## Fire Marshal Division

**Re: Carolina Wildlife Park  
1096 Patterson Rd.  
Broadway, NC 27505**

**Application Number BCOM-1811-0005**

UTILITY SHED 10' X 10'

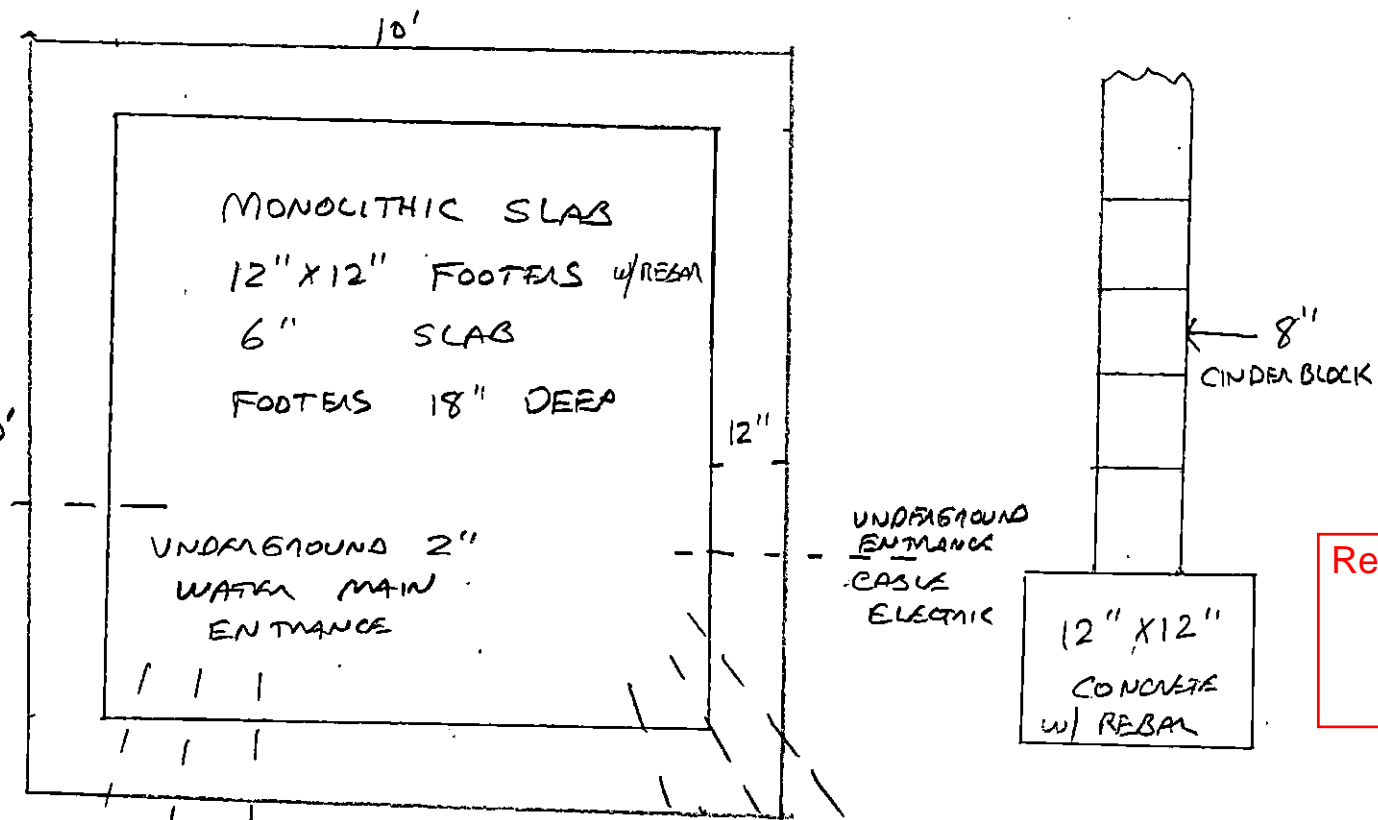
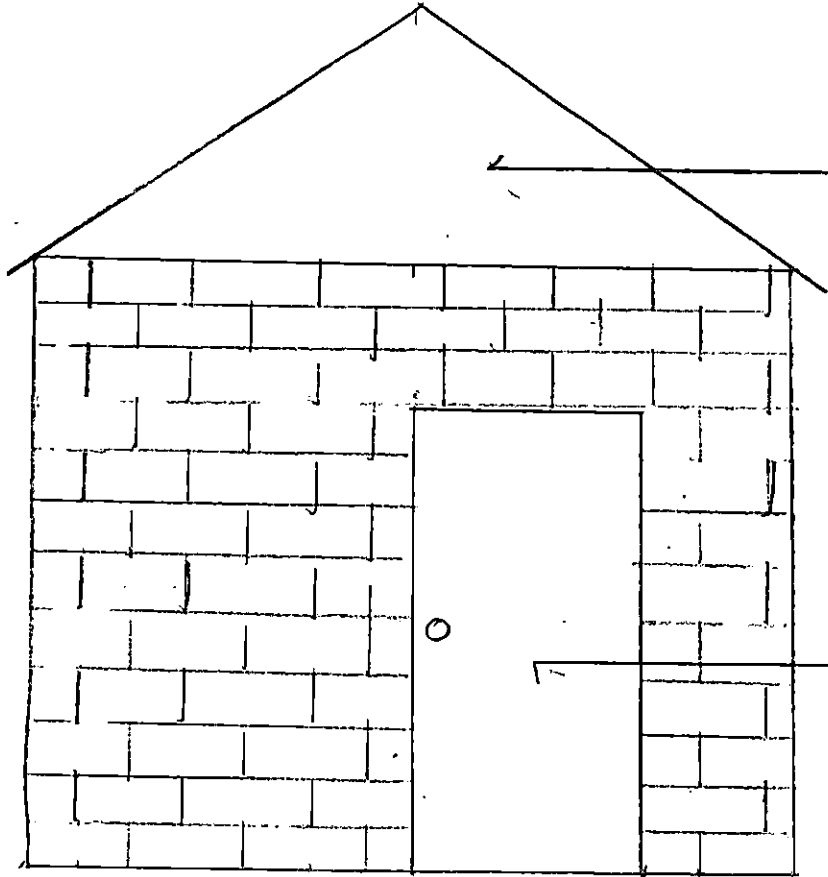
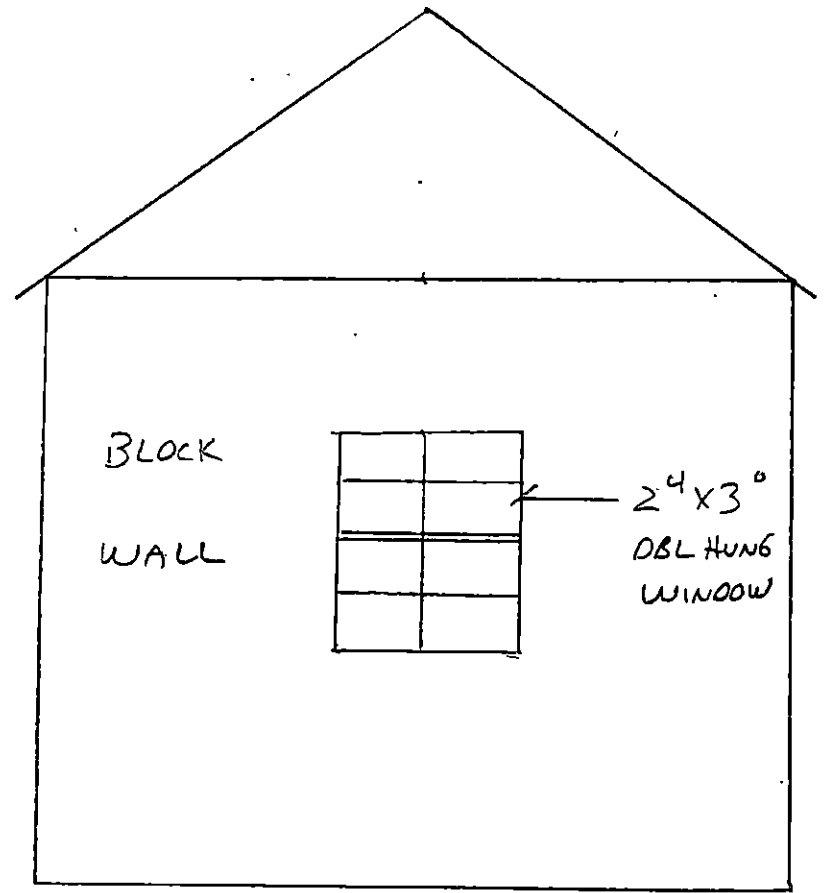
- **505.1 Physical Address**
  - The physical address of the site shall be posted in a conspicuous place so that it can be seen on approach from the road, access road, and/or parking lot.
  - The numbers used to make up the physical address shall be at least 5 inches in height.
